Submission in relation to Kilbarry SHD Ref: 313994

I refer to development proposal Kilbarry Strategic Housing Development reference number: **313994**

Figure 5-2: Surface Water Catchments

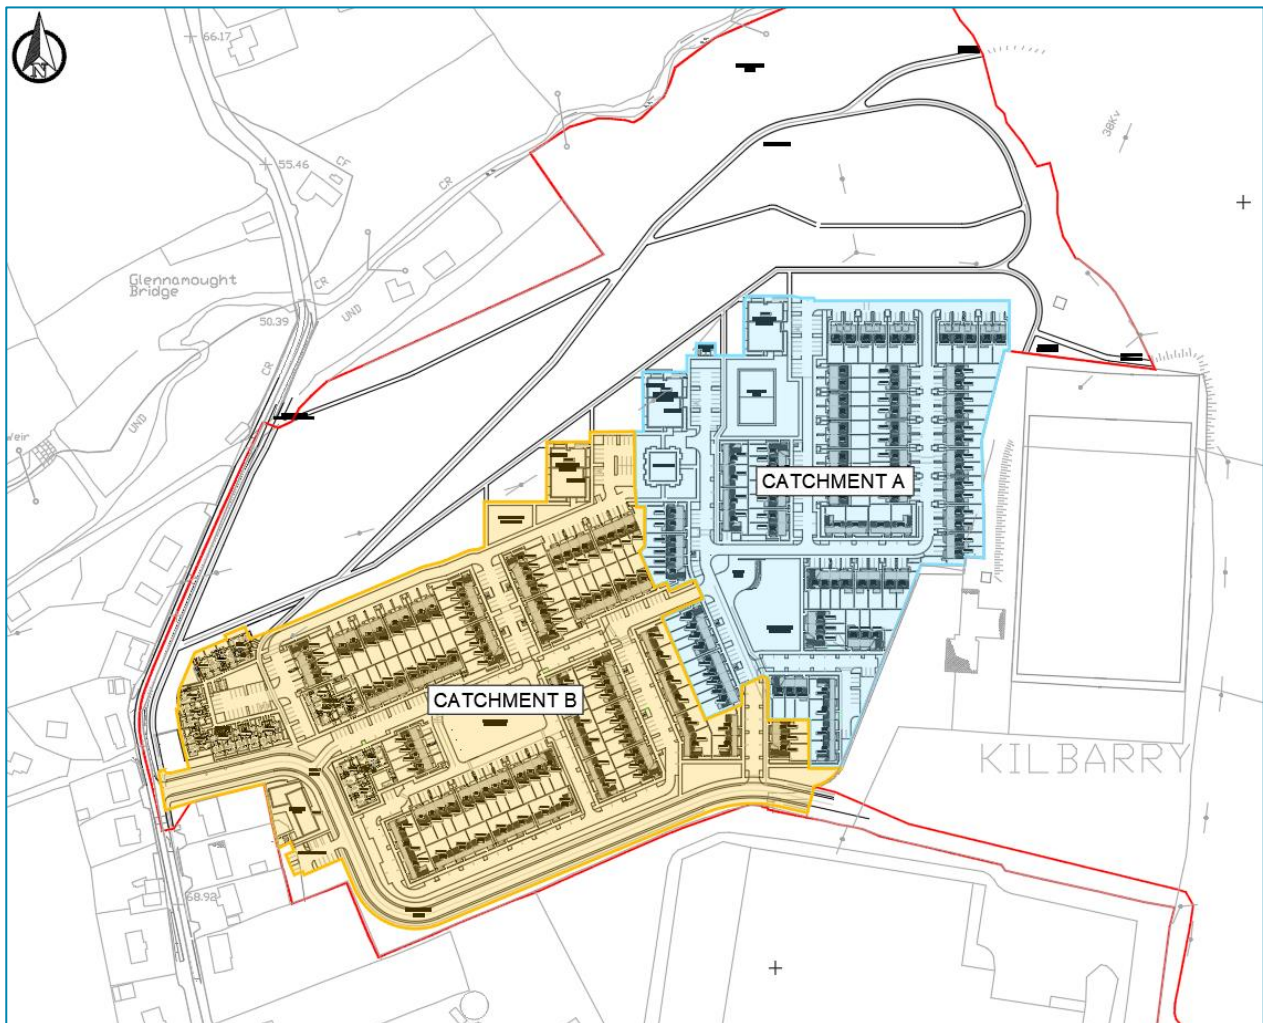
The developers propose to dispose of surface water from this large housing project (via attenuation tanks) into the Glenamought Stream which runs along the Northern boundary of the site. The Services Infrastructure Report accompanying the proposal quotes a figure of 26.2l/s.
